Letter No: ~~DD~~ A2/12479/92 dt: 1-12-92

sub: MMDA - Planning permission - Construction of
Additional
residential building at plot no 238,
S.No 77/7pt & 77/8pt of Thiruvanniyur village

SITE PLAN

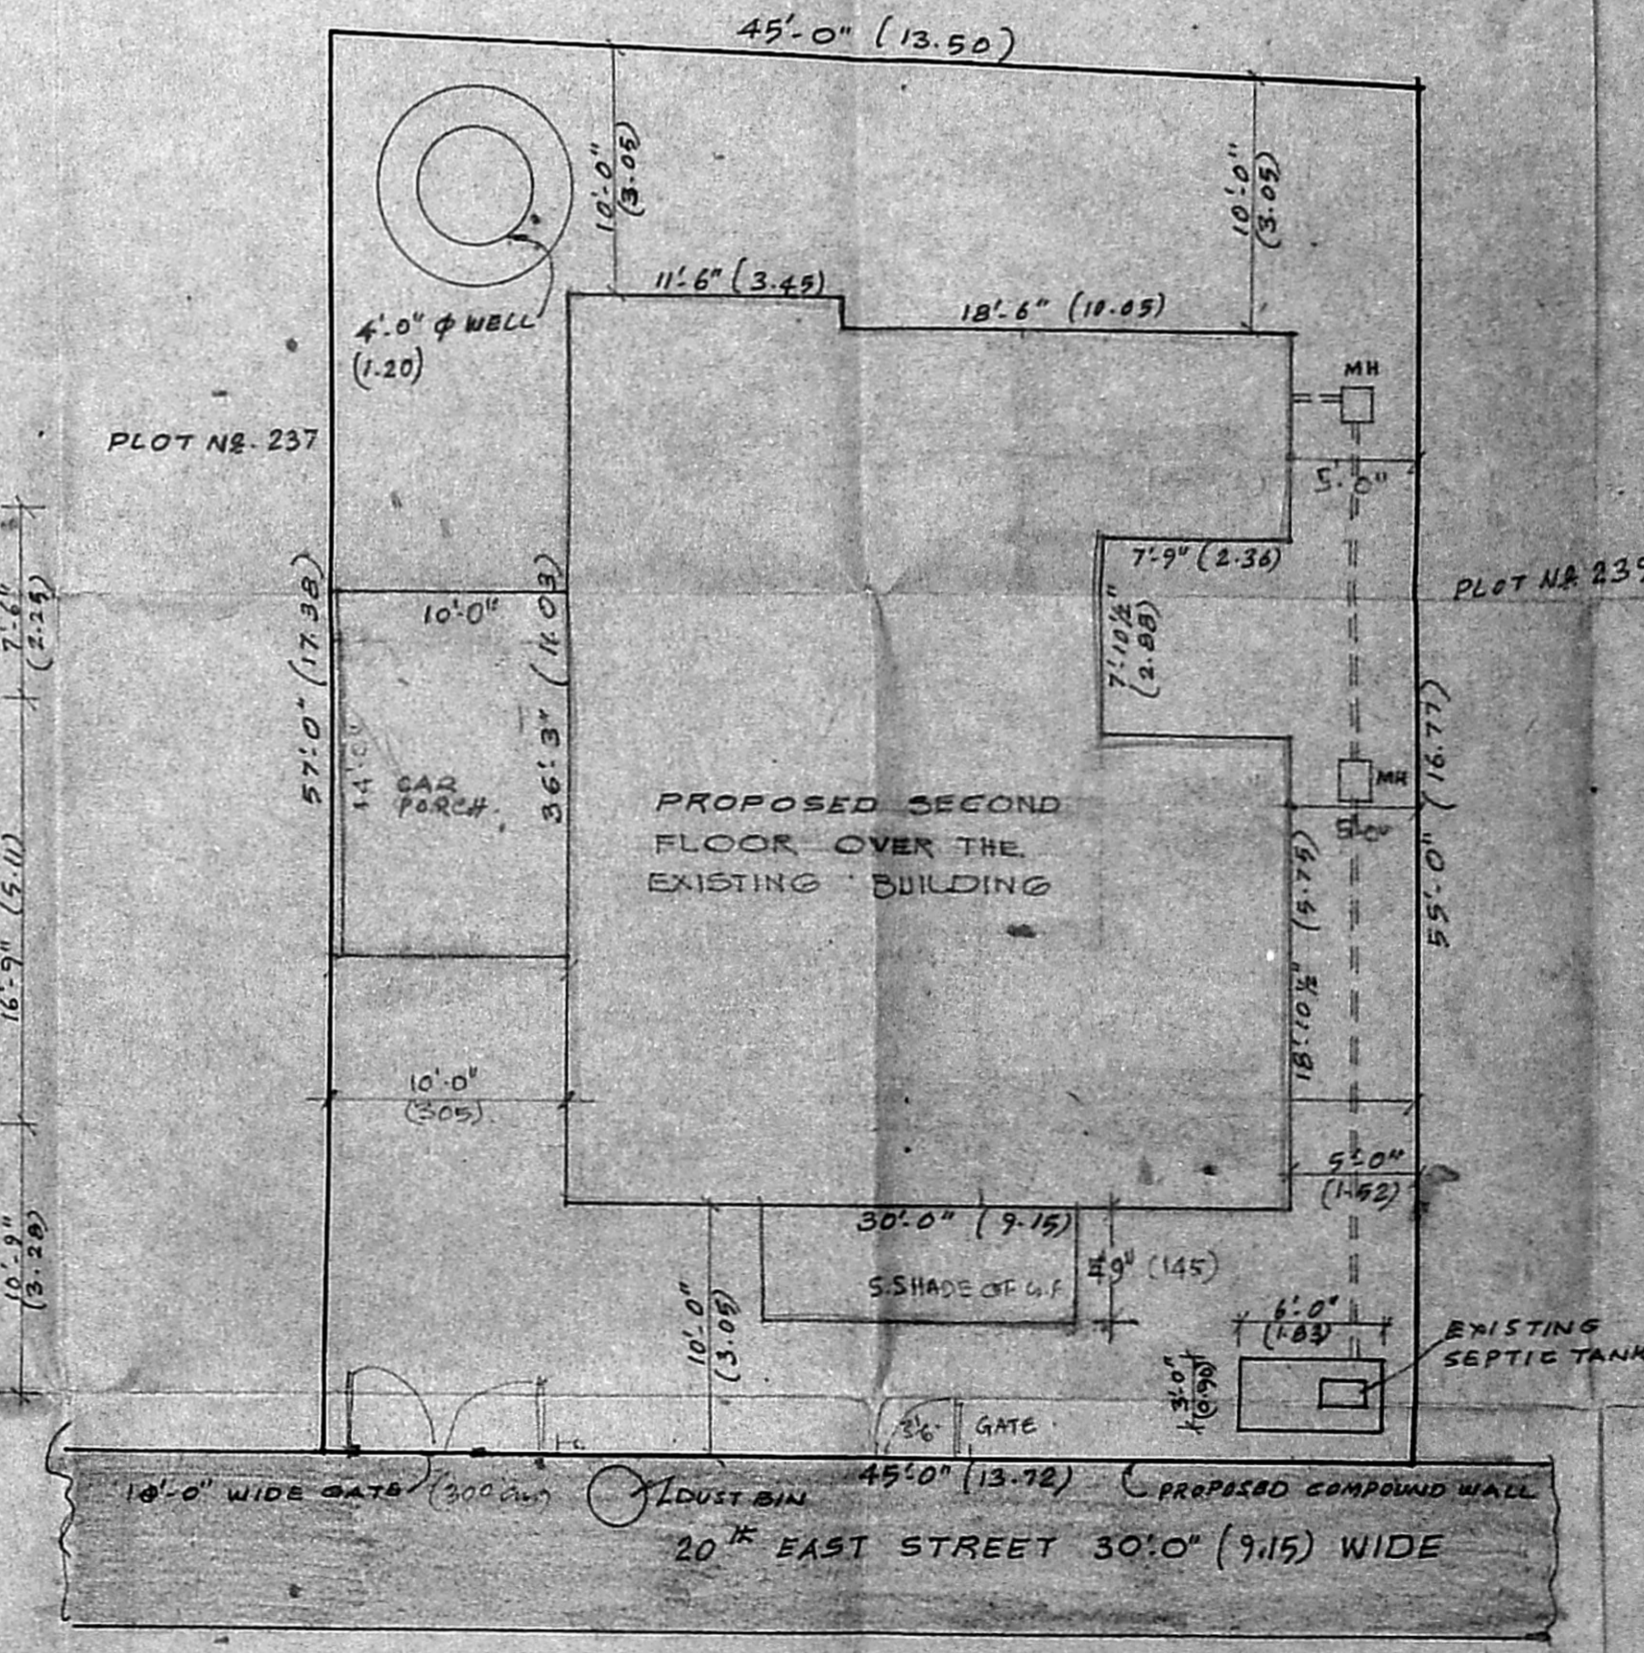
i) ^② By relaxing the RSB violation 'in the open space within the site to the extent feasible trees be planted and the existing tree as preserved'.
